DECISION DELEGATED TO HEAD OF PLANNING

Application No: H05-0353-24 **Applicant:** Mr & Mrs Jones

Proposal: Change of use of part of paddock to residential curtilage, extensions and alterations to dwelling including new gated entrance

Location: Ravensdale Bens Gate Fleet

TITLE: Gated Entrance - As Proposed

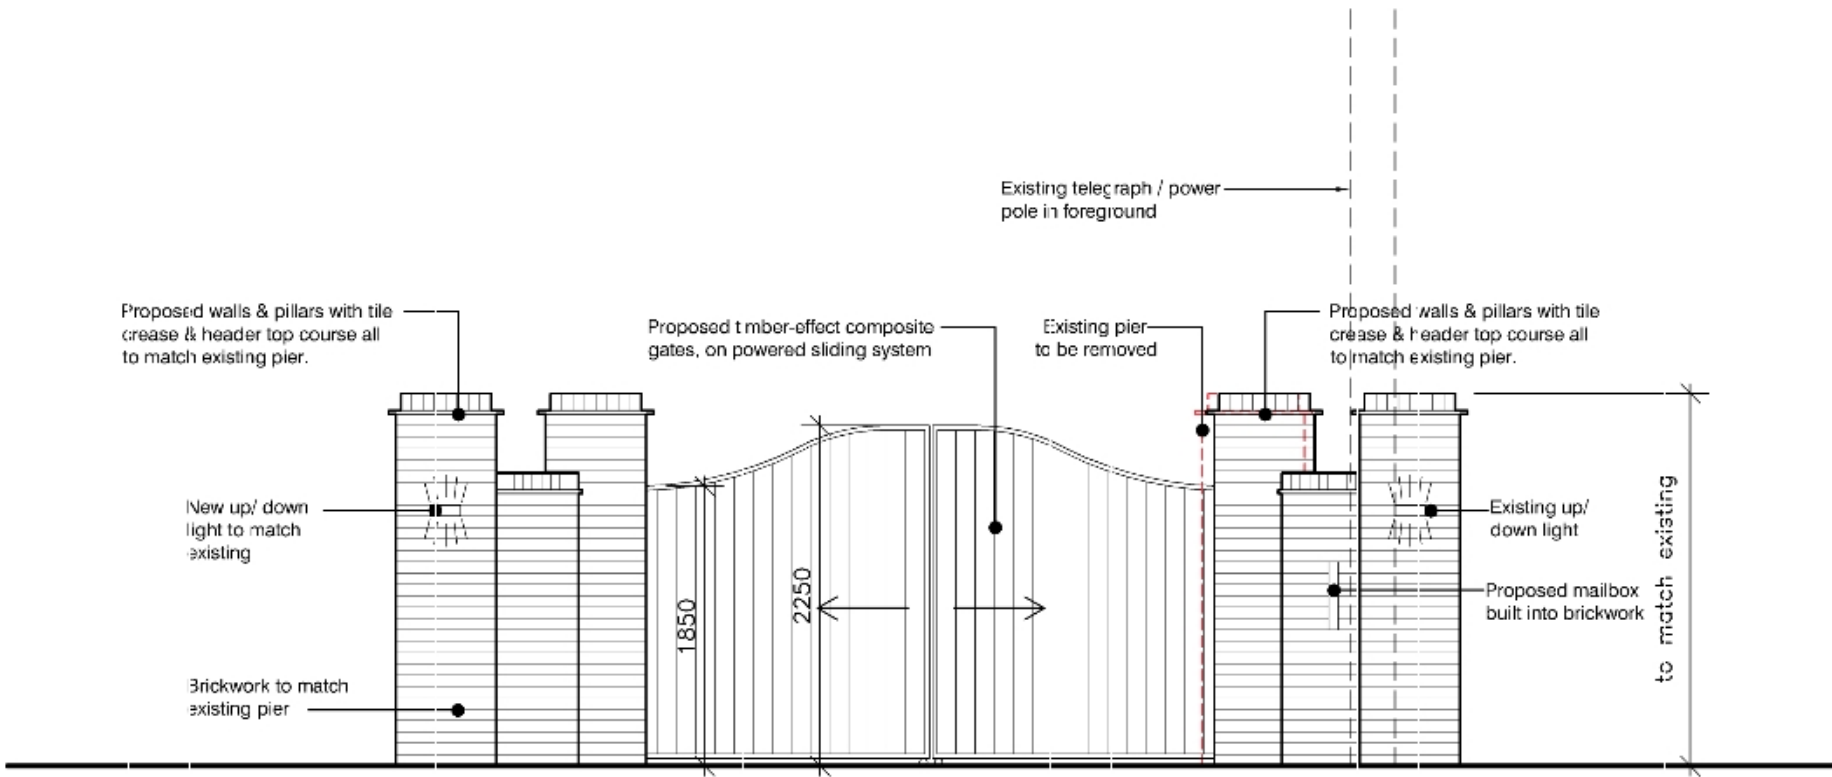
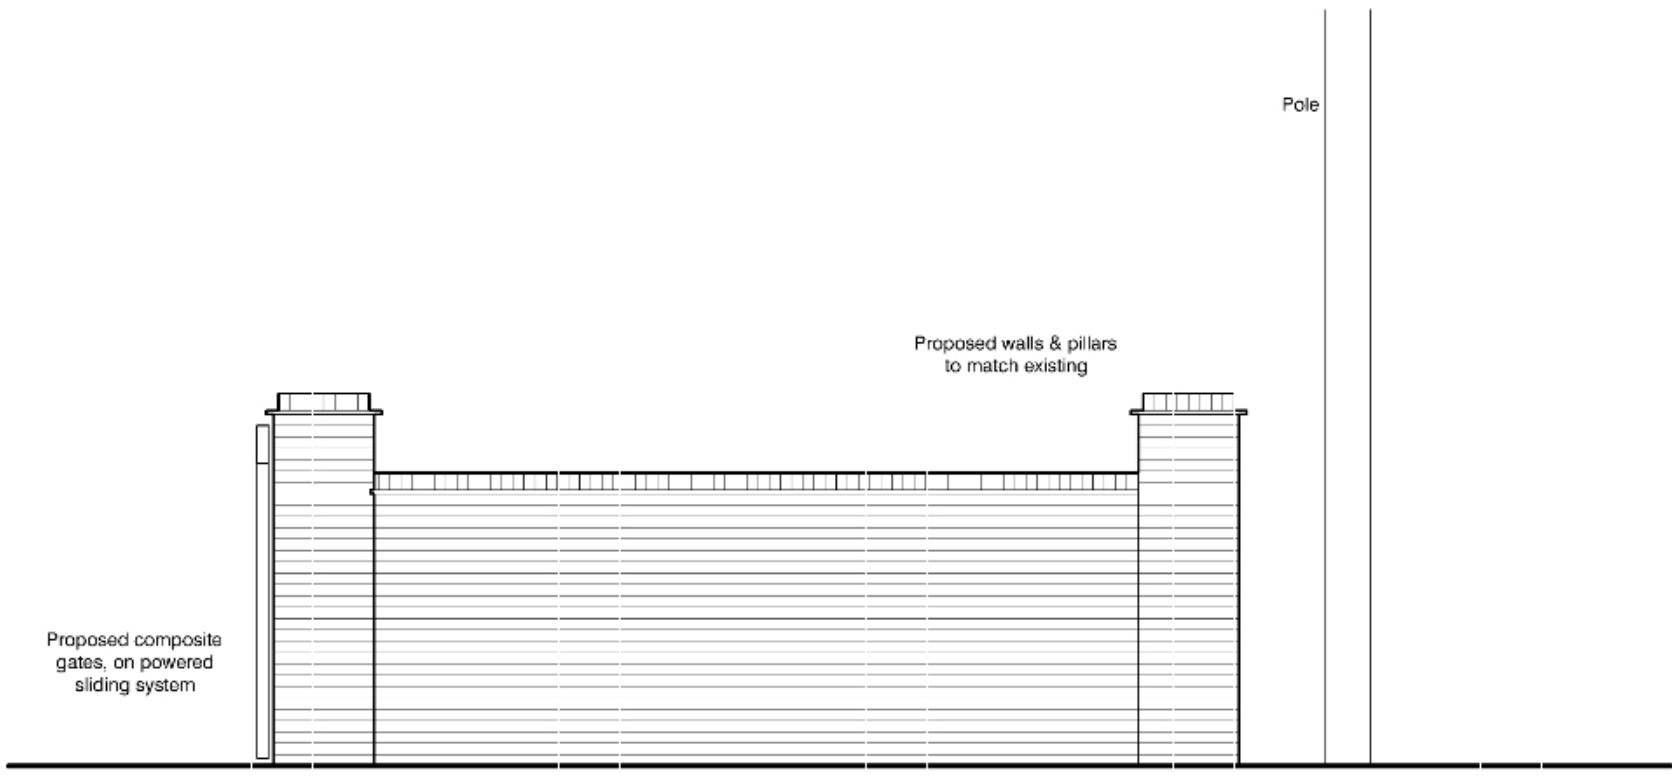
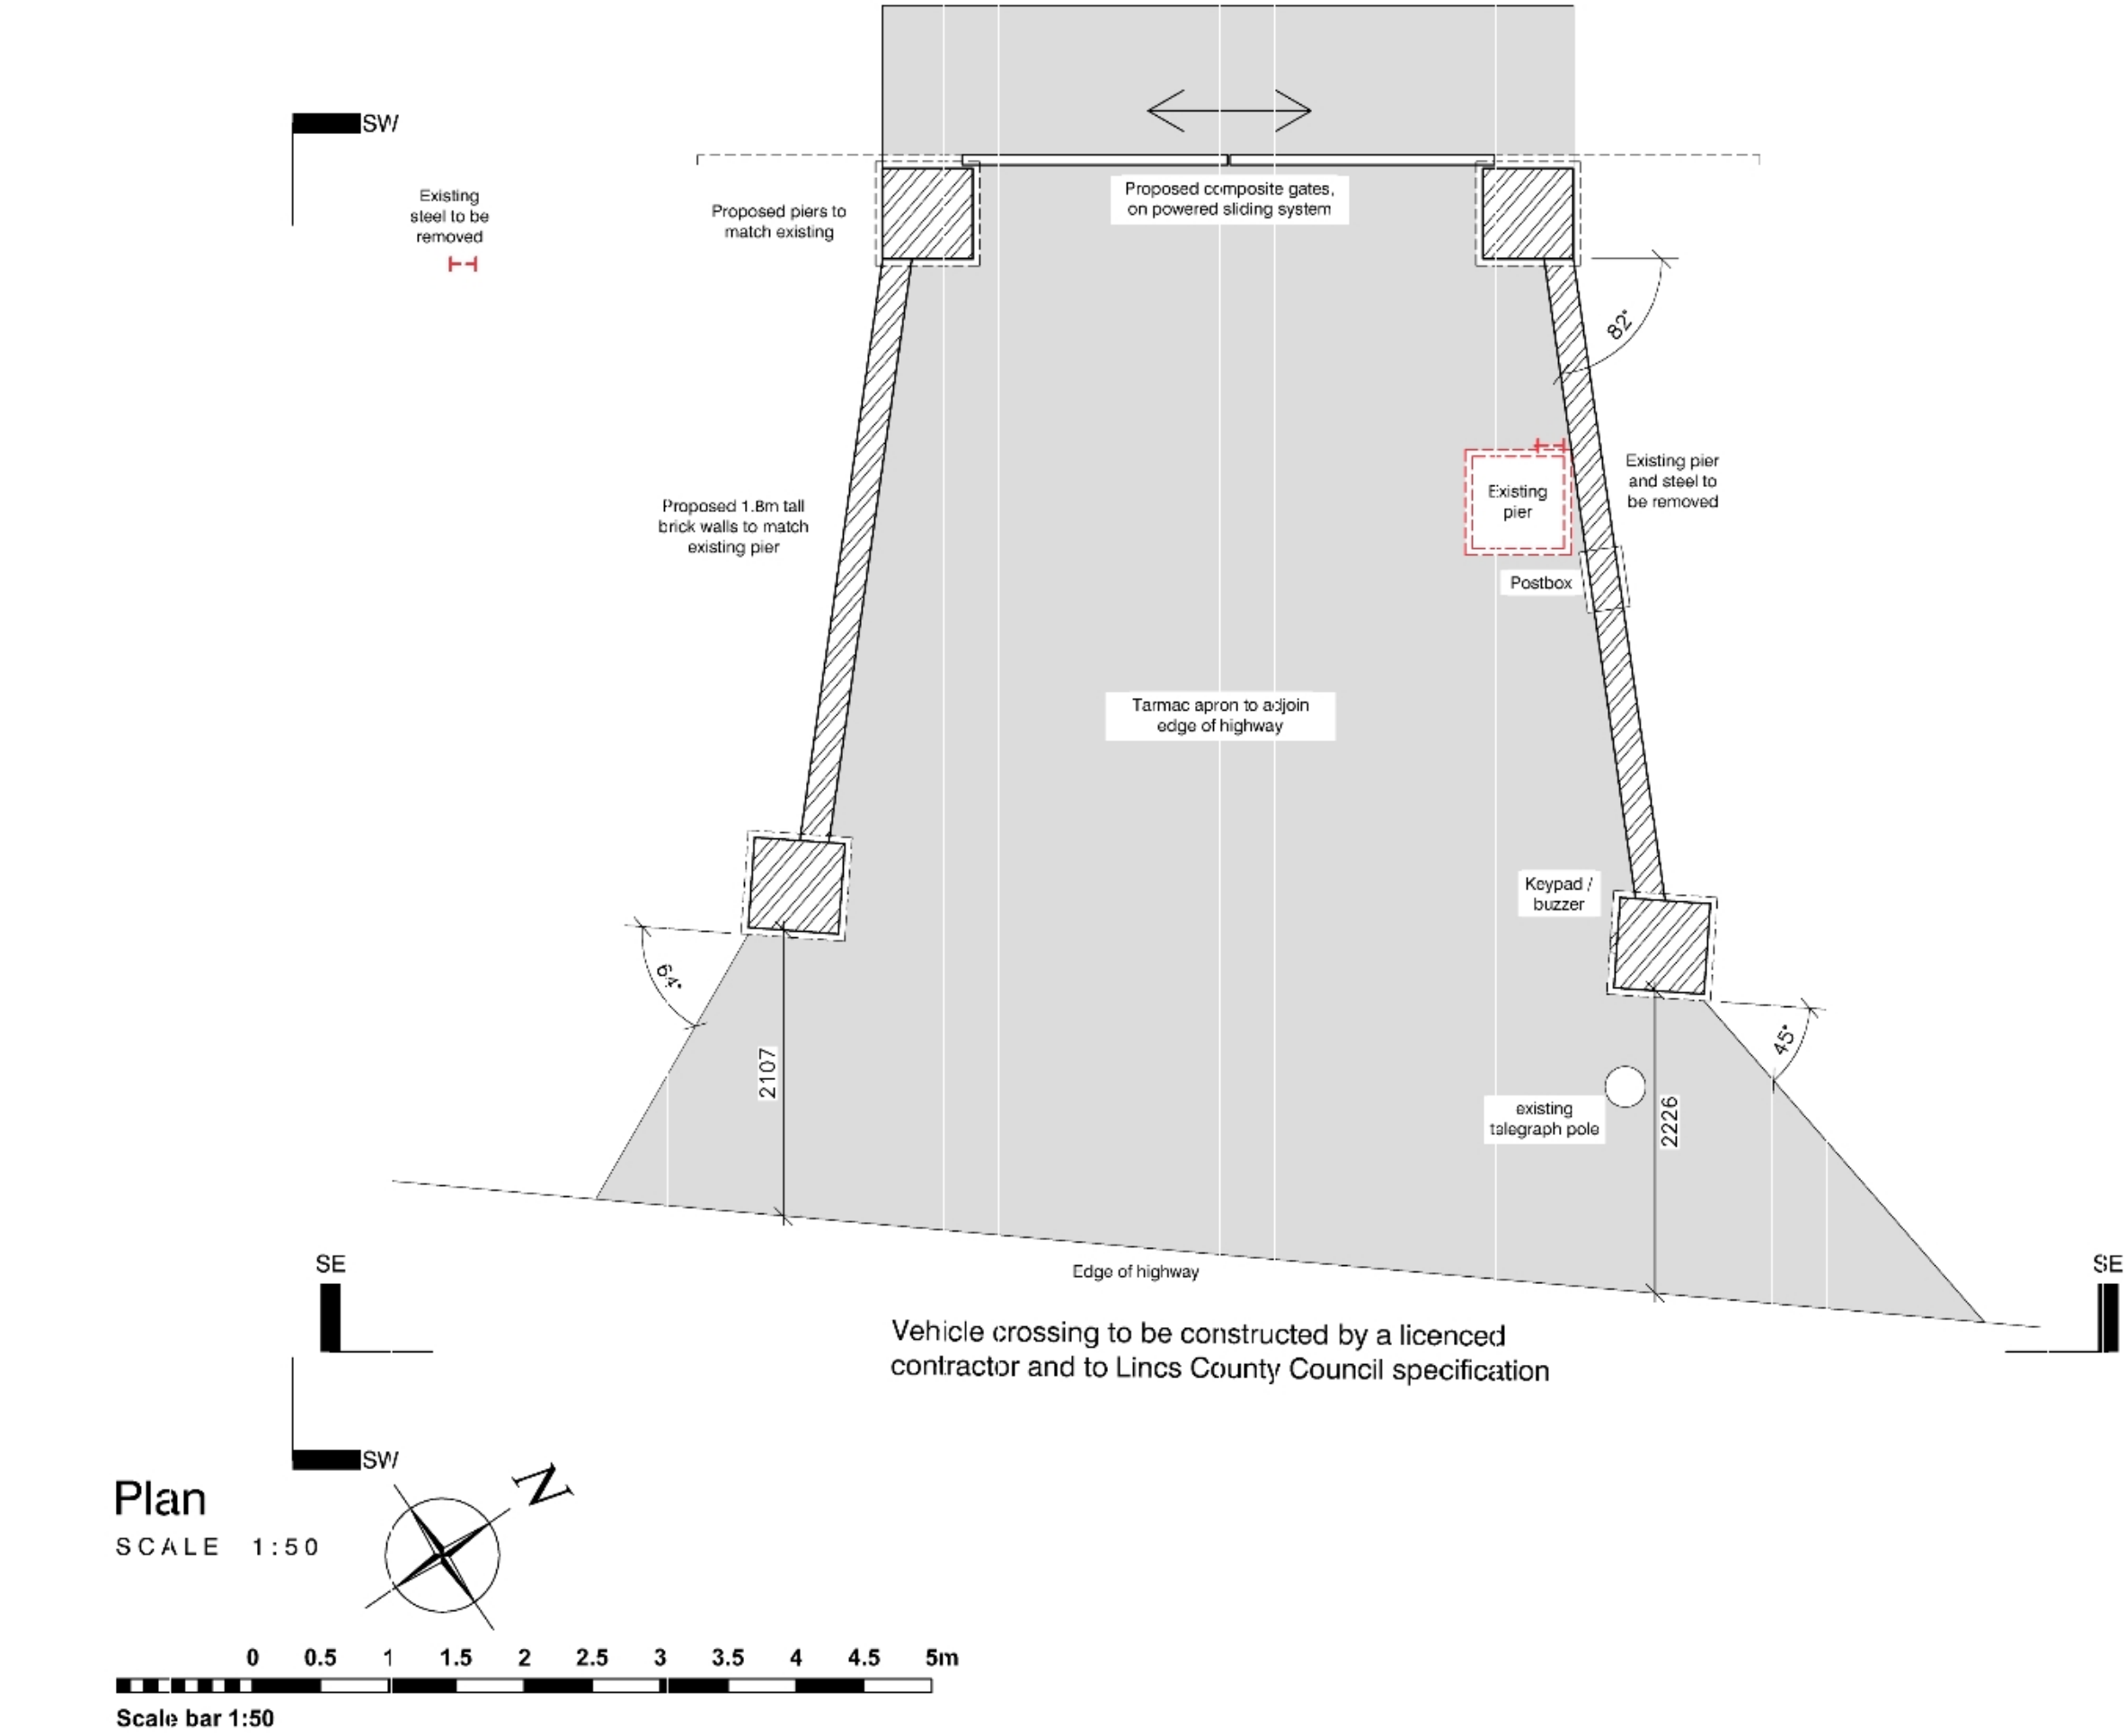
The proposed block plan shows two pillars which are not indicated as proposed, but they do not currently exist on site. One of the pillars is just in the red outline and one is out of the red outline. The one outside of the red outline is in the public highway which is not permitted. I would question the impact the proposed pillars will have on the visibility when entering the highway. The visibility currently is restricted by the existing hedging to the east and if anything, this needs to be improved but should not be made worse.

The sliding gate should have at least 5m clearance from the highway boundary so that vehicles will not overhang the highway whilst waiting for the gates to open.

The access should be constructed to Lincolnshire County Council specification and a note should be added to the proposed block plan. Block paving is not permitted.

New walls and piers will be sited to the front entrance of the site, the piers closest to the highway will both be set over 2m away with the closest being 2107mm and the furthest being 2226mm. To the rear of this, there will be a 1800mm wall which runs until the rear most piers, around 4300mm and 4700mm respectively. These rear posts are the same height as the front - furthermore they are also the same height as an existing pier that is on site currently which holds weight in the assessment of these proposed plans. The brickwork used on the piers will also match the existing, there shall be up/down lights on the front side with proposed walls and pillars featuring tiles crease and header top course also to match. This ensures that minimal visual discrepancies should arise. Finally, the gates will be made from timber effect composite and will be 1850mm at the lowest level and 2250mm at the highest level. It is worth noting that the highest point of the pier is still only 400mm over the maximum height allowed under permitted development which further benefits the scheme as a whole and improving its acceptability.

The proposal is for the change of use of part of paddock to residential curtilage, extensions and alterations to dwelling including new gated entrance. 4 parking spaces exist and 6 are proposed. There is sufficient space to allow all calling vehicles to turn on site and leave in a forward gear. The access exists, visibility will be improved with the proposal and the visibility drawing should be conditioned so that it is maintained and the new yew hedging should not exceed the specified height. The access will be upgraded to Lincolnshire County Council Specification and there is sufficient space fronting the gates for vehicles to wait clear of the highway. The proposal will provide a betterment to the users of the site and the users of the public highway. As Lead Local Flood Authority, Lincolnshire County Council is required to provide a statutory planning consultation response with regard to drainage and surface water flood risk on all Major applications. This application is classified as a Minor Application and it is therefore the duty of the Local Planning Authority to consider the surface water flood risk and drainage proposals for this planning application.
